Hearing Action Points

A30 Chiverton to Carland Cross

Action points arising from the Walking, Cycling and Horse riding Hearing, 10am
Thursday 4 April 2019

Scale	1:2500	By	HJ	Checked	LP	Approved	RC	Authorised	SW
Original Size	A1	Date	17/04/19	Date	17/04/19	Date	17/04/19	Date	17/04/19
Drawing Number	HA551502 - SW	Originator	ARP	Volume	LSI	Revision	C04		
			-DR - ZL - 000503

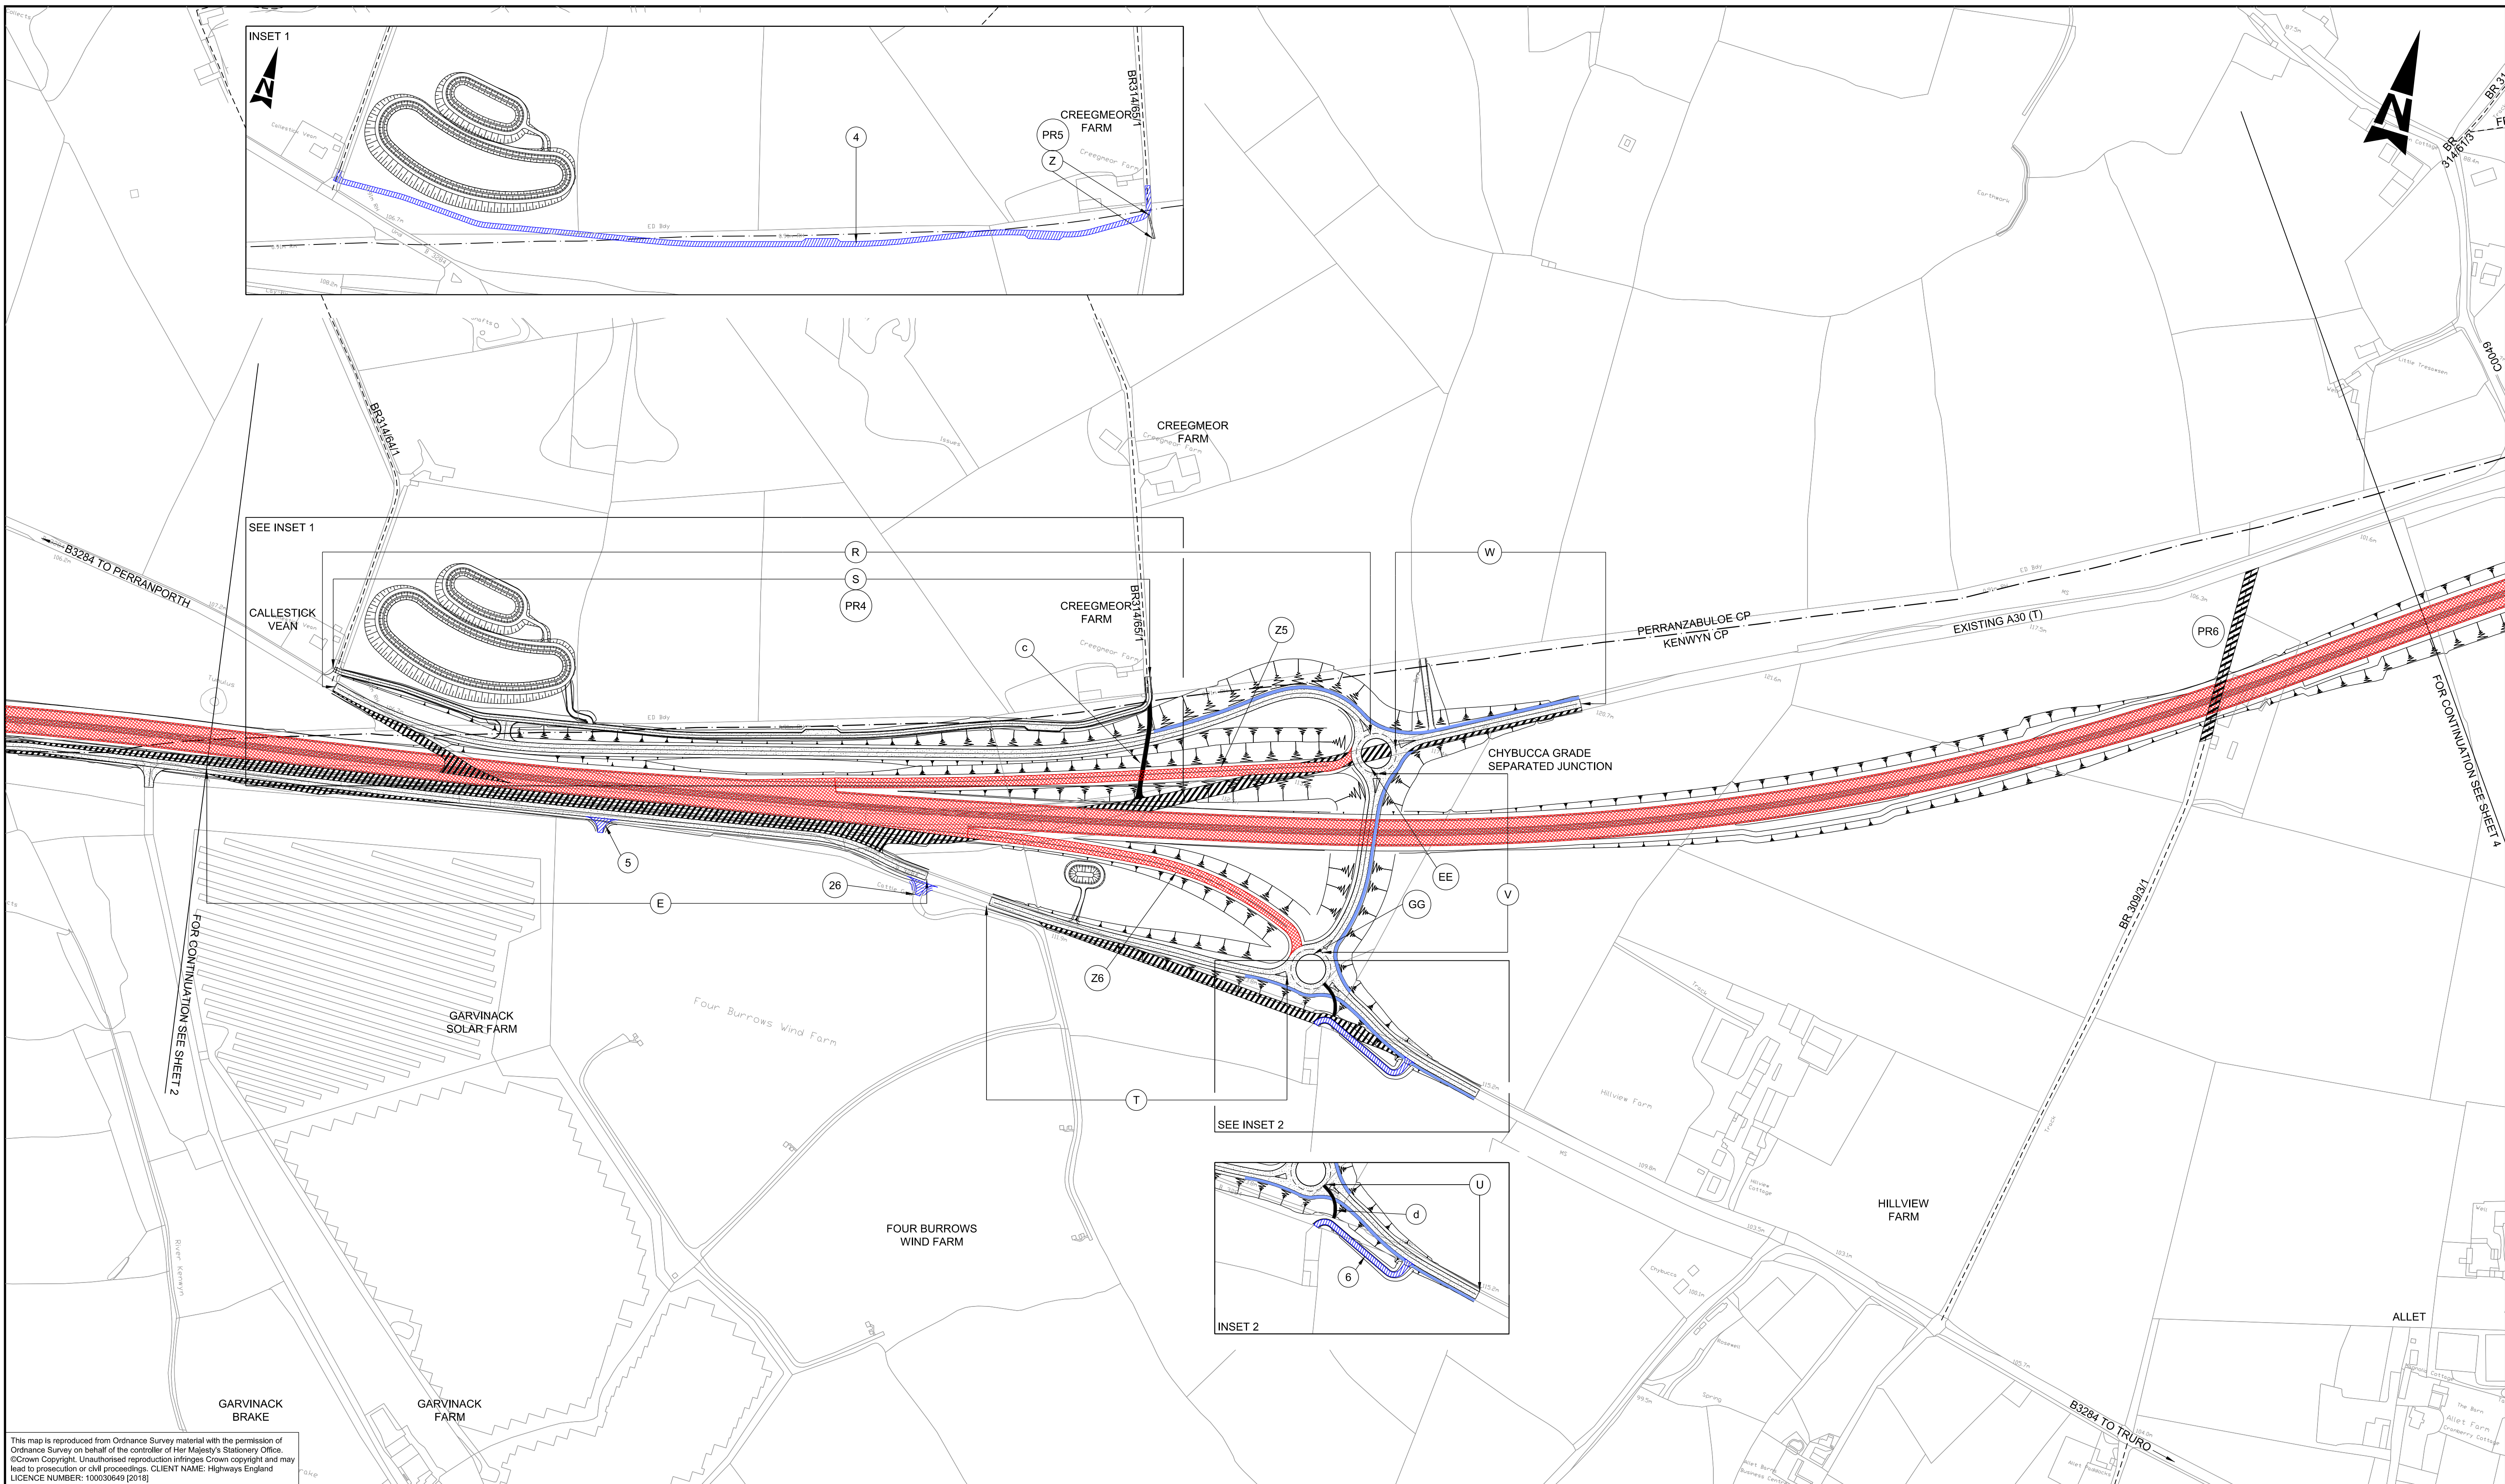
Action	Party	Deadline
1	Clarification of position regarding potential link west from the existing Chiverton roundabout area to existing BOAT 309/25/7	HE CC	3
2	Clarification of position regarding potential higher rights link in the area shown on Rights of Way and Access Plans Sheet 3-ref. Z (PR5)	HE CC	3
3	Summary of position regarding the section of the Shortlanesend road from St Fredas to Two Burrow Hill, which forms part of the National Cycle Path (route no. 32).	HE CC	3
4	Summary of position regarding potential further links east from the northern end of Kenwyn BR3	HE CC	3
5	Comments on possibility of additional signage to that proposed at Carland Cross for westbound cyclists at Mitchell to encourage earlier off-road use	HE CC	3
6	Confirmation of the status of the section of route to west of end of proposed bridleway VV	CC	3
7	Clarification of any additional requirements arising from the outcome of point 7	HE CC	4
